WEST SUSSEX COUNTY COUNCIL CONSULTATION

TO:	Arun District Council FAO: Anita Gardner
FROM:	WSCC - Highways Authority
DATE:	2 November 2020
LOCATION:	Land at former McIntyre Nursery Littlehampton Road Ferring BN12 6PG
SUBJECT:	FG/123/20/PL Demolition of a polytunnel, storage building & scaffolders' shelters & racking, use of land for Class B8 container self-storage & the siting of 79 No. single-stacked storage containers, part regrading of the ground, new fencing, CCTV & lighting. This site is in CIL Zone 3 (Zero Rated) as other development & is a Departure from the Development Plan.
DATE OF SITE VISIT:	Access known to Planning Officer
RECOMMENDATION:	Advice / No Objection
S106 CONTRIBUTION TOTAL:

TITLE
PROPOSED SITE & BLOCK PLAN

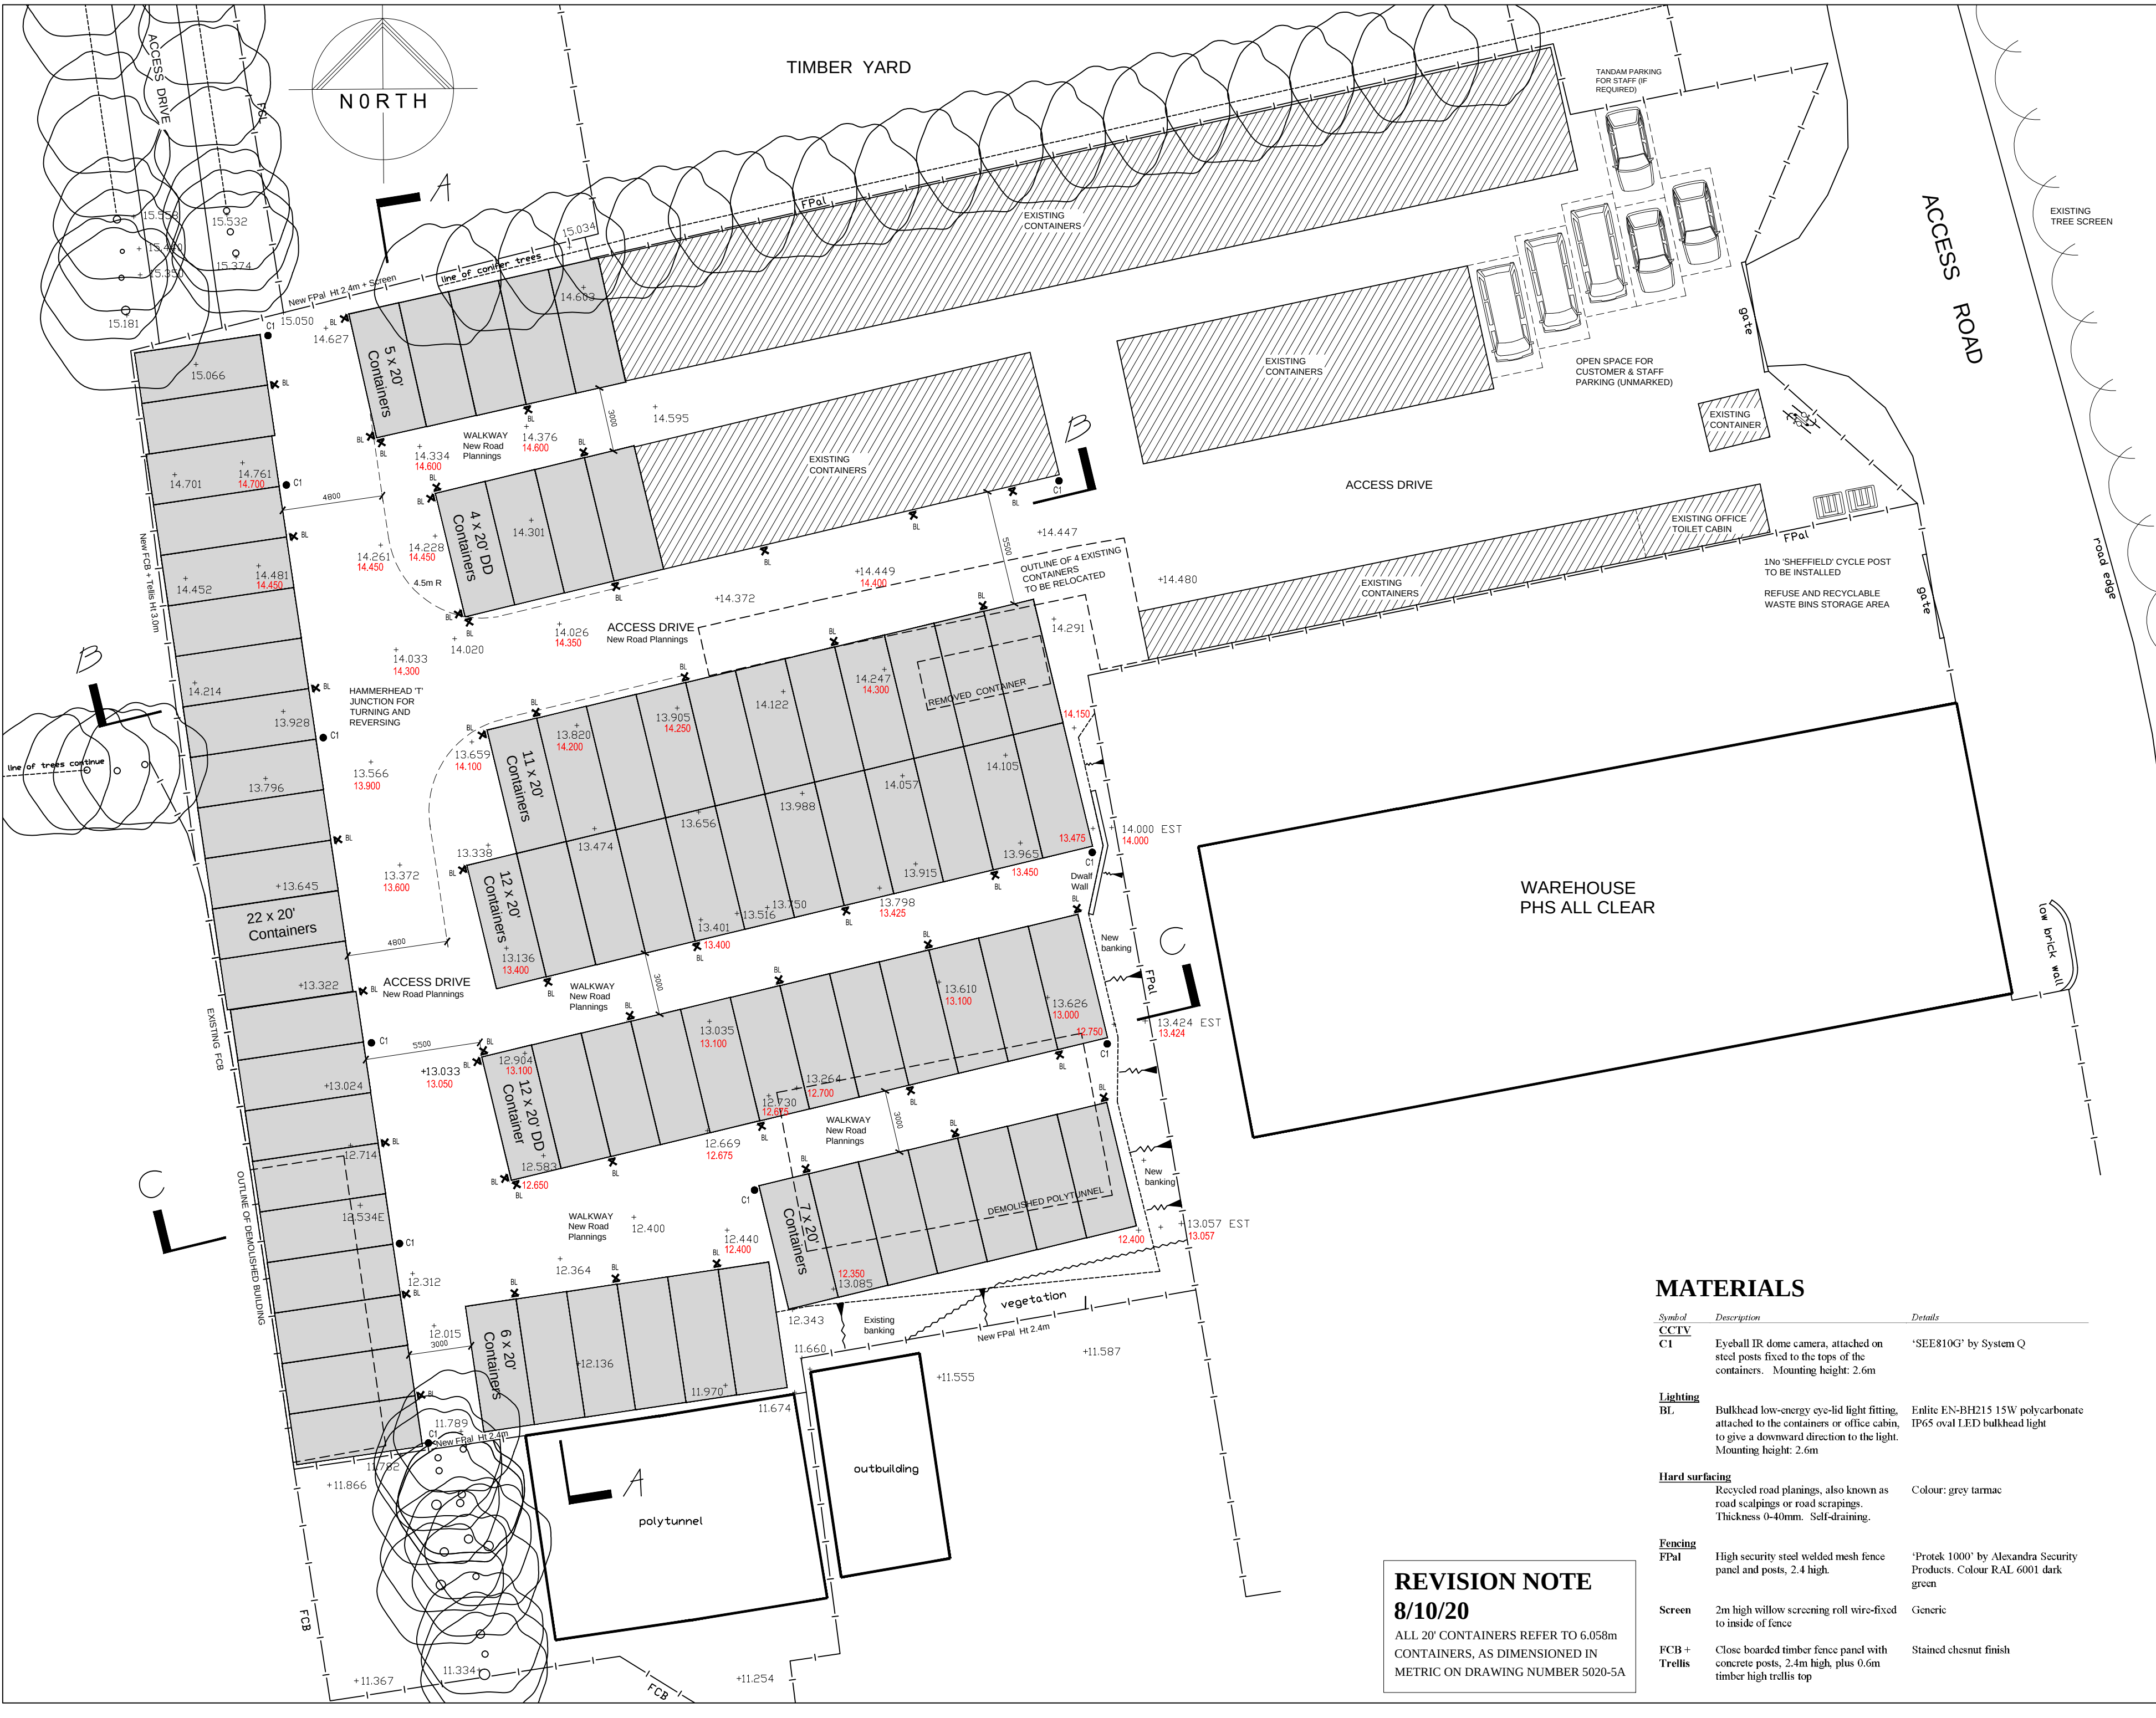
In terms of parking the application doesn't meet the WSCC Guidance on Parking at New Developments (Sept 2020). Under B8 Storage use we would expect to see 1 space provided per 100sqm of storage space. The Design & Access Statement indicates that 6 spaces will be provided. With the proposal we would expect to see 8 additional spaces. Bearing in mind there is already 205 sqm of B8 use on the site, the LHA would highlight that the parking provision is slightly under provided for. However, there appears to be space on site to park that would not interfere with the safety or operation of the highway network.

Car parking space (details required)

No part of the development shall be first occupied until the car parking spaces have been constructed in accordance with plans and details to be submitted to and approved in writing by the Local Planning Authority. These spaces shall thereafter be retained at all times for their designated use.
